Our Reference: SYD17/00959/02 (A21220667)
DP&E Reference: SSD 8378

NEW GLEDSWOOD HILLS PUBLIC SCHOOL – LOT 3 THE HERMITAGE WAY, GLEDSWOOD HILLS

Reference is made to your correspondence dated 15 January 2018, regarding the abovementioned Application which was referred to Roads and Maritime Services (Roads and Maritime) for comment.

**Figure 3 – Location of Bus Bay and Drop Off Zone**

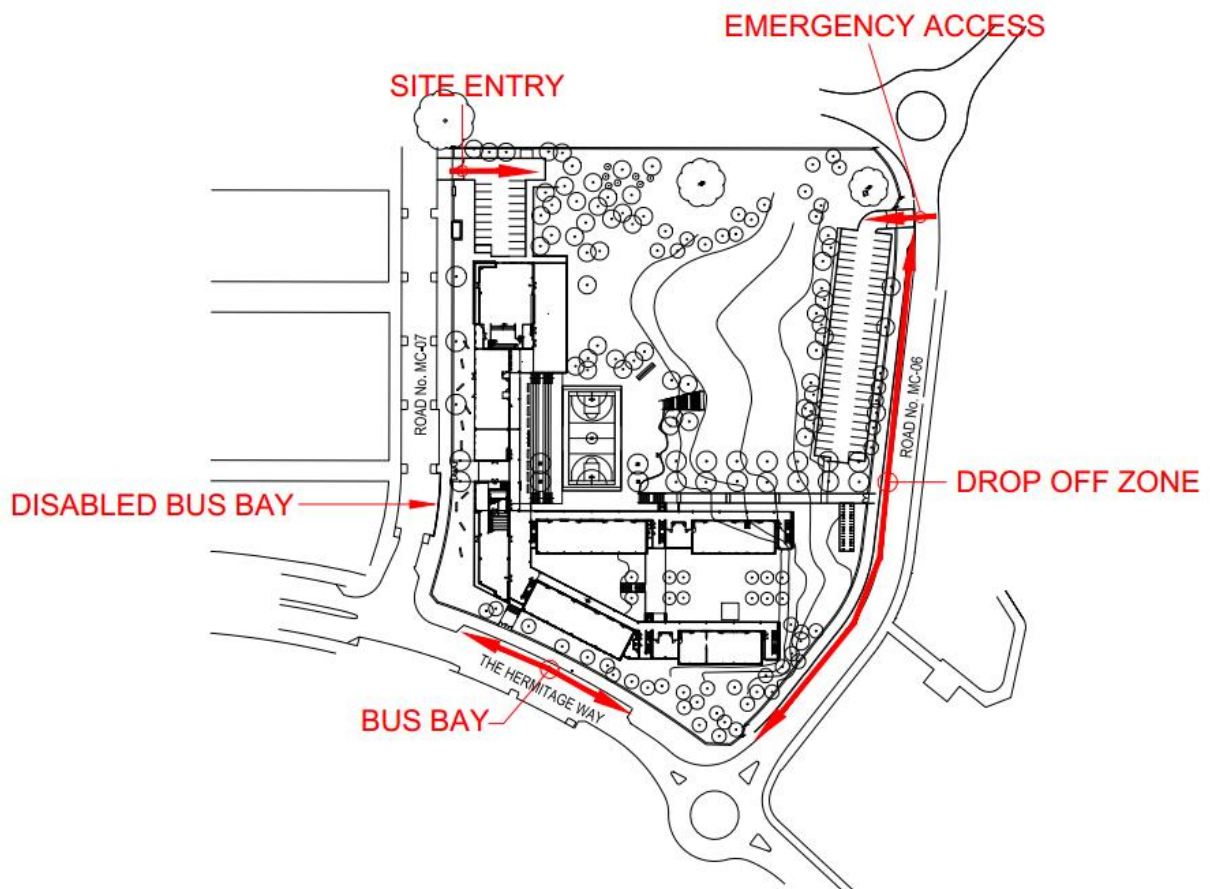
1. A significant number of vehicles and pedestrians will access the site at the start and end of the school day. School Zones must be installed along all roads with a direct access point (either pedestrian or vehicular) from the school. School Zones must not to be provided along roads adjacent to the school without a direct access point. Road Safety precautions and parking zones should be incorporated into the neighbouring local road network and 40km/hr School Zones are to be installed in accordance with the conditions below. The consent authority should ensure that parking, drop-off and pick-up zones and bus zones are incorporated in accordance with Roads and Maritime standards.

CONSTRUCTION TRAFFIC  
PLAN

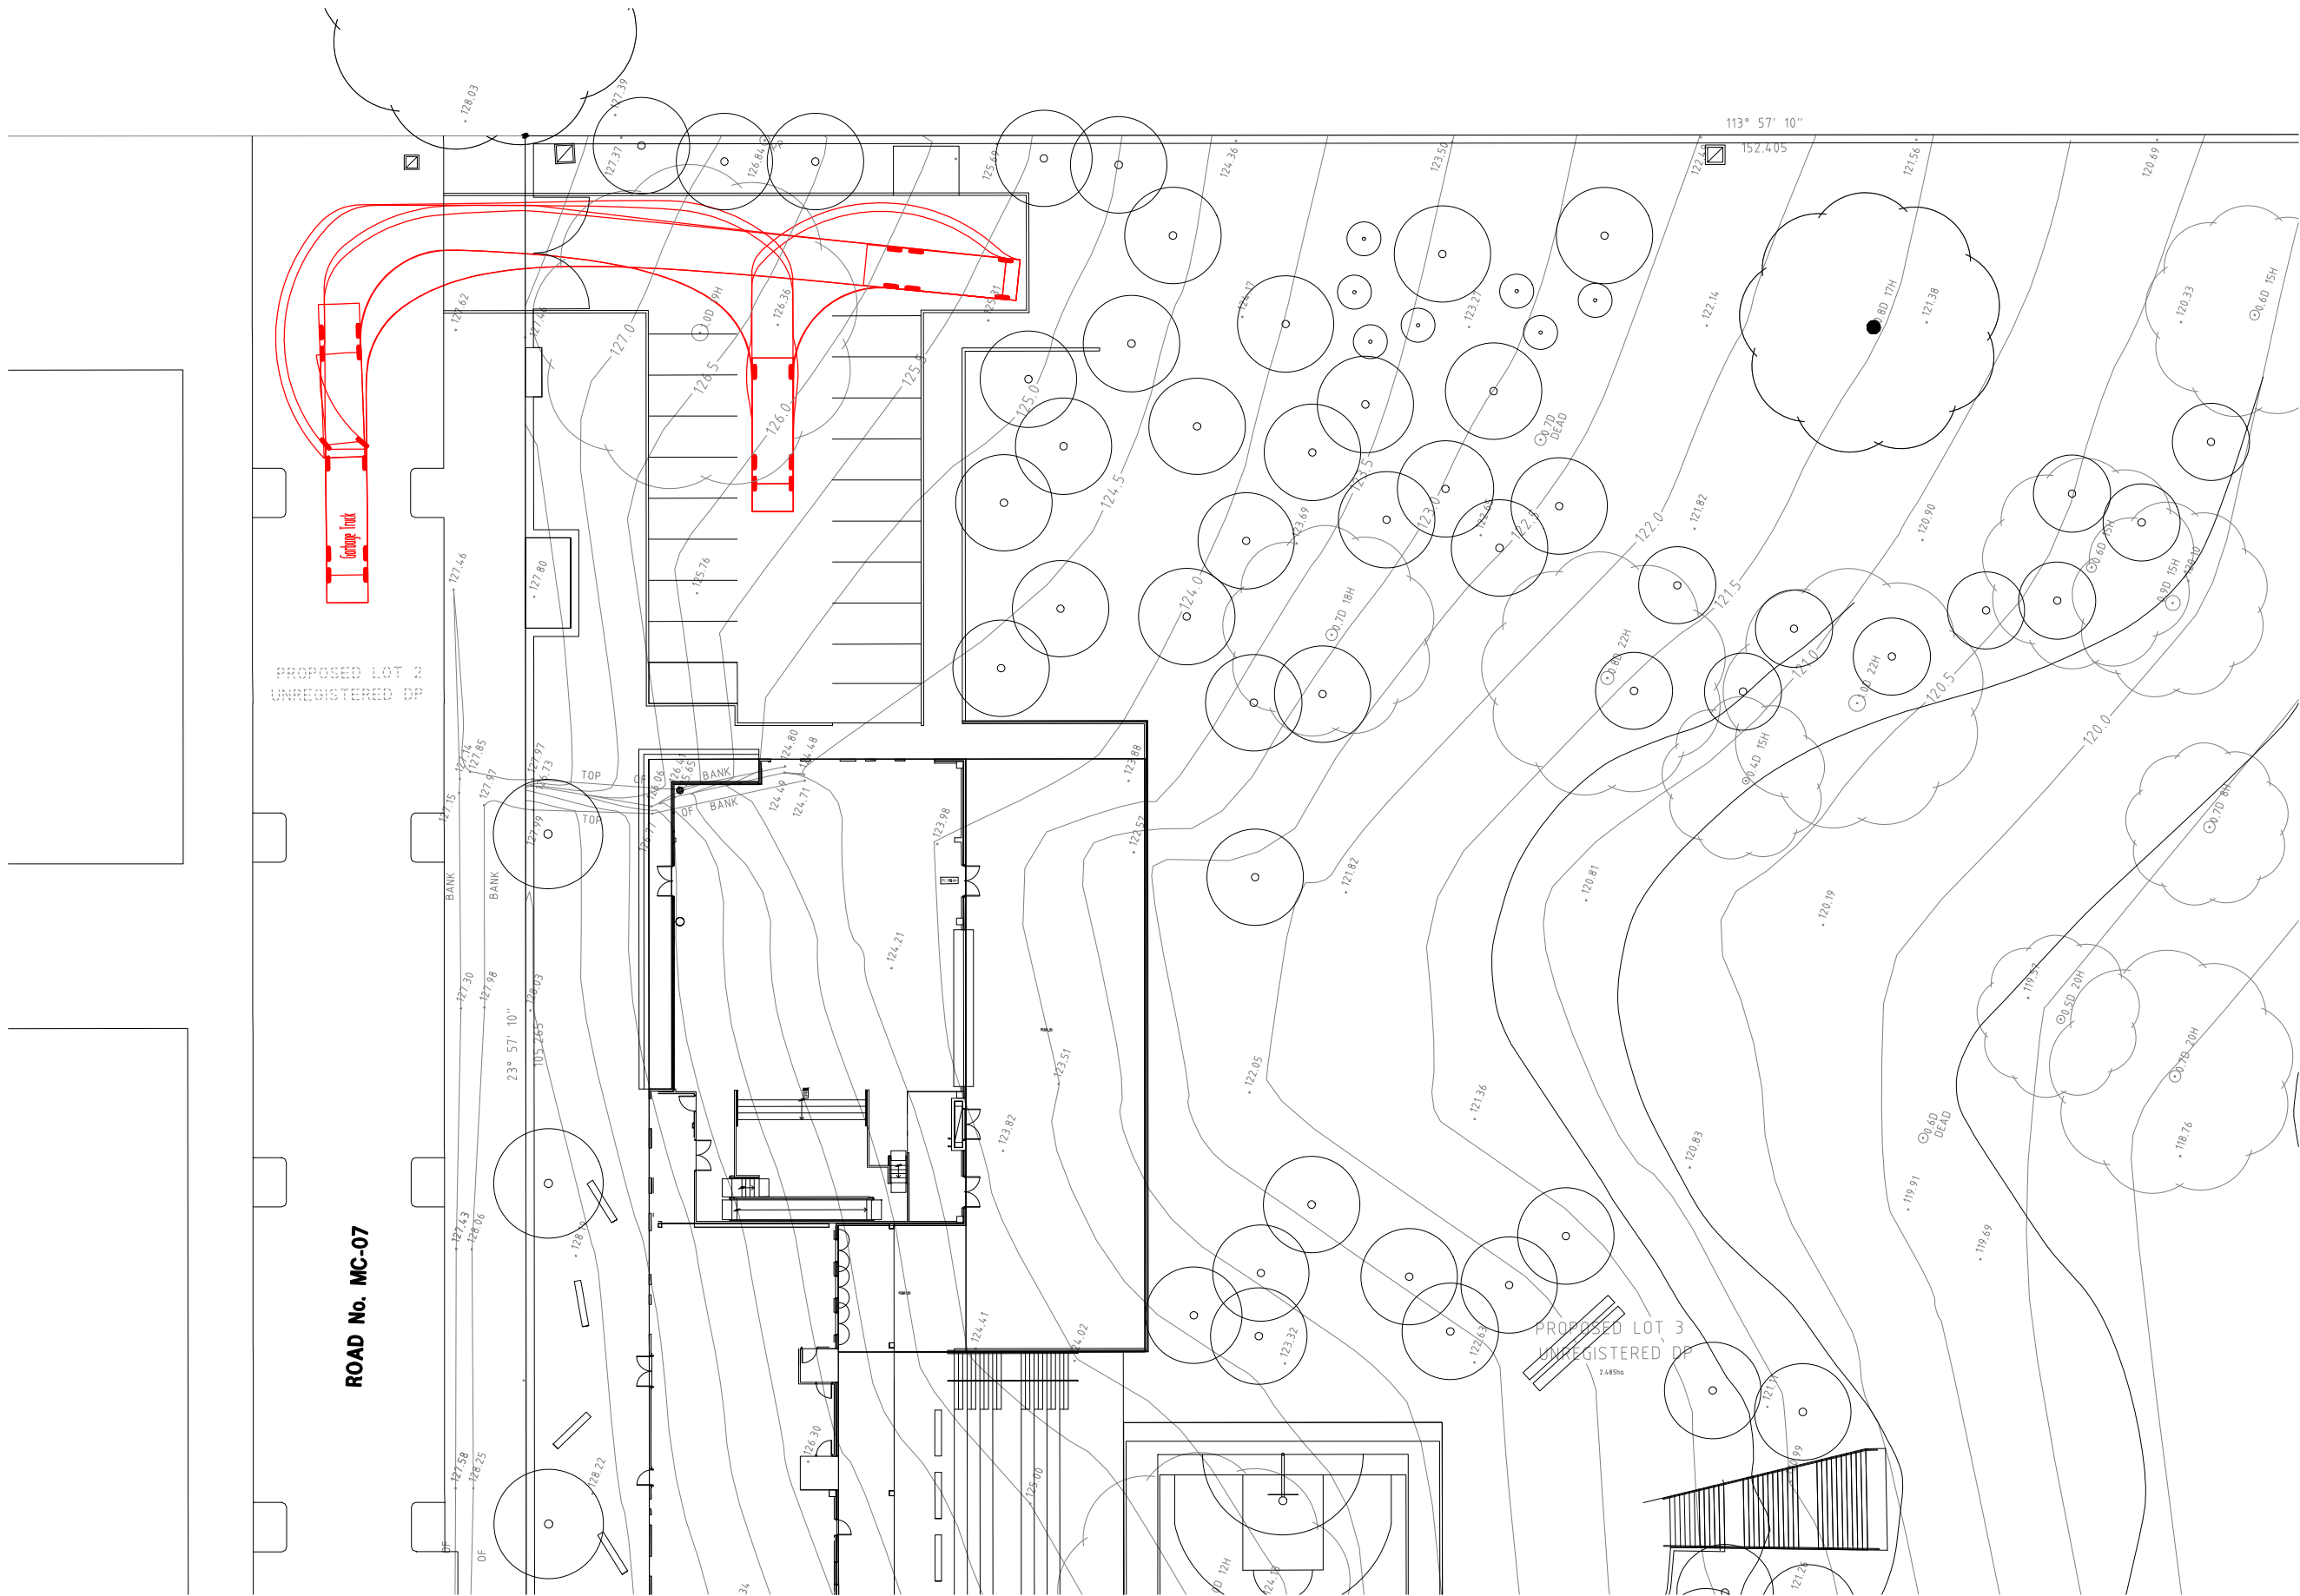
- 6. A Construction Traffic Management Plan detailing construction vehicle routes, number of trucks, hours of operation, access arrangements and traffic control should be submitted to the relevant consent authority for approval prior to the issue of a Construction Certificate.
